From: Manchester, Sarah [Sarah.Manchester@env.lancscc.gov.uk]
Sent: 18 December 2007 09:28
To: Jane Tucker
Subject: re: planning application 03/07/0964 - Barrow Brook Business Village

APPLICATION 03/07/0964
DETAILS PROPOSED B1 OFFICE DEVELOPMENT (REVISION TO APPROVED MATTERS
APPLICATIONS, BARROW BROOK BUSINESS VILLAGE)

Schematic Layout 5

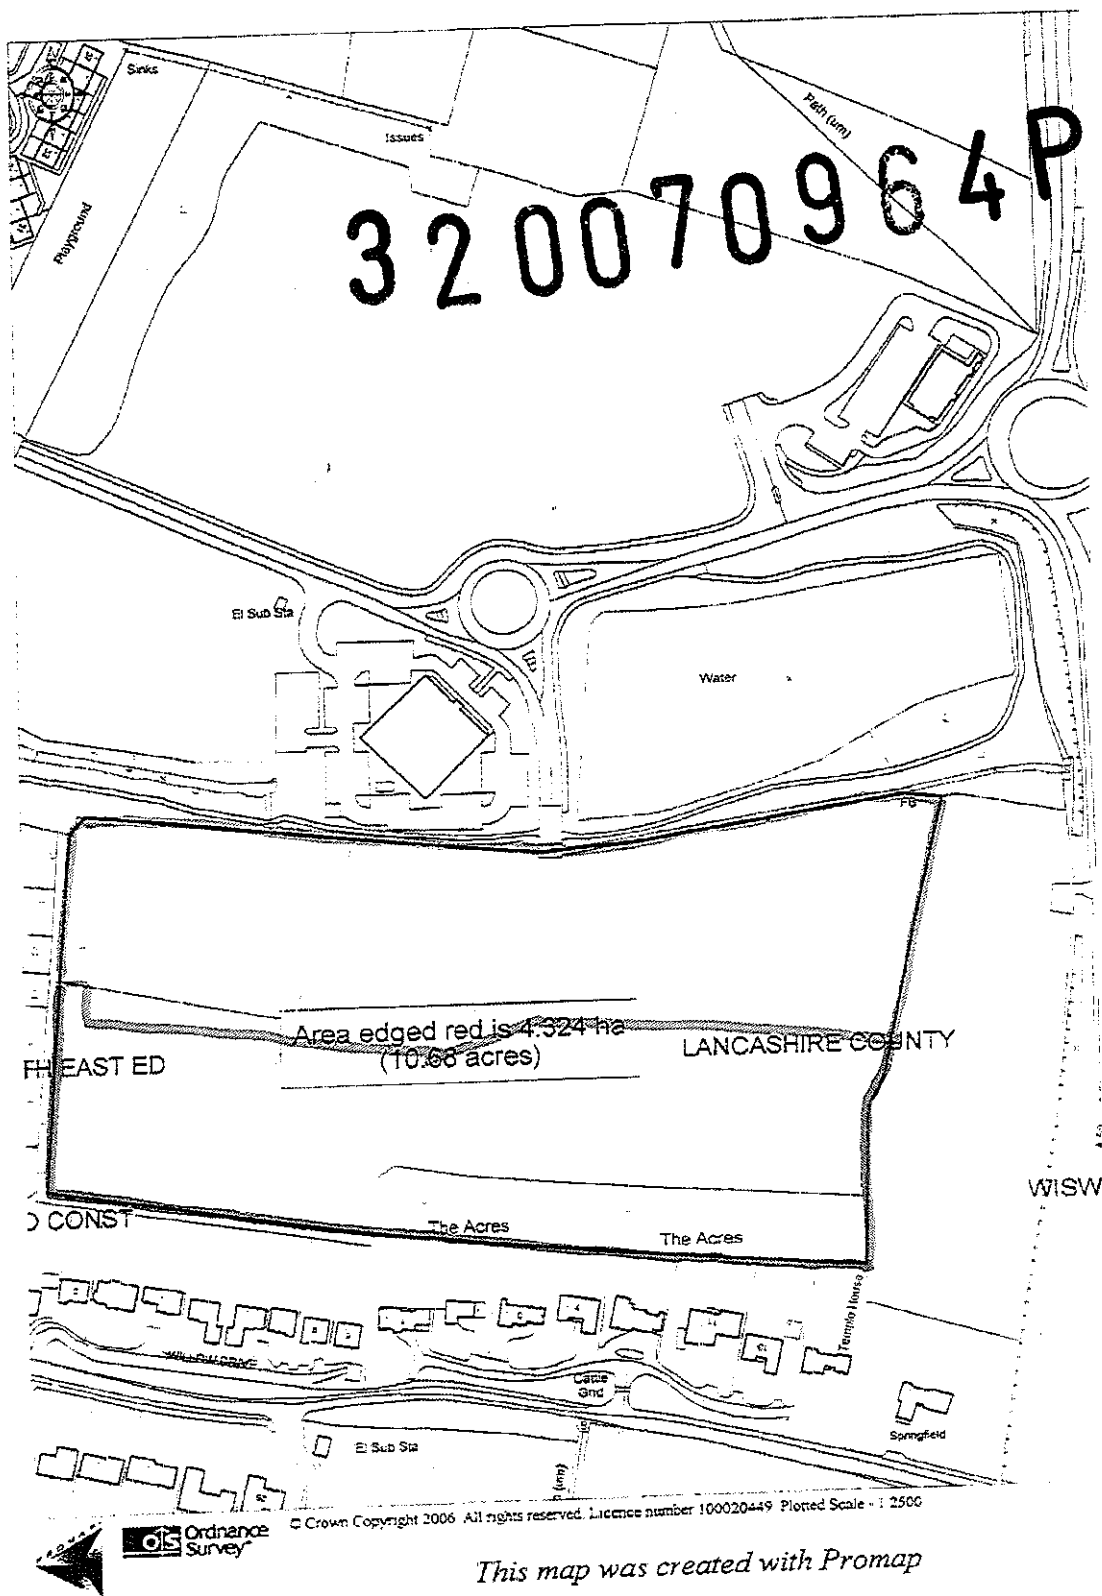
It appears from the submitted plans that a section of existing hedgerow would be destroyed by the proposals. A hedgerow assessment would therefore be desirable. The Joint Lancashire Structure Plan Supplementary Planning Guidance on Landscapes and Heritage states that the presence of an important hedgerow is regarded as a material consideration above and beyond that afforded to hedgerows in general. If Ribble Valley Borough Council is minded to permit the removal of a section of an important hedgerow, then suitable mitigation/compensation measures should be the subject of a planning condition in order that there is no net loss of the resource.

It appears that a number of the existing trees would be retained within the development. However, from the Scheme Layout (drawing no. 1502/114E) it appears that construction activity would occur under the canopies of many of these retained trees. This is unlikely to be appropriate, and may compromise the long-term survival of retained trees. I therefore recommend that all trees are assessed by a suitably qualified arboriculturalist, and those that are being retained should be adequately protected (e.g. according to guidelines contained within BS 5837: 2005 Trees in Relation to Construction: Recommendations).

Maintaining and enhancing habitat connectivity within the application area and the wider landscape needs to be addressed in the overall design of the development. I am particularly concerned that the proposals appear to be extremely close to Barrow Brook in places. Ideally at least an 8m wide, appropriately landscaped buffer zone should be incorporated into the proposed development in order to maintain and enhance connectivity along the watercourse.
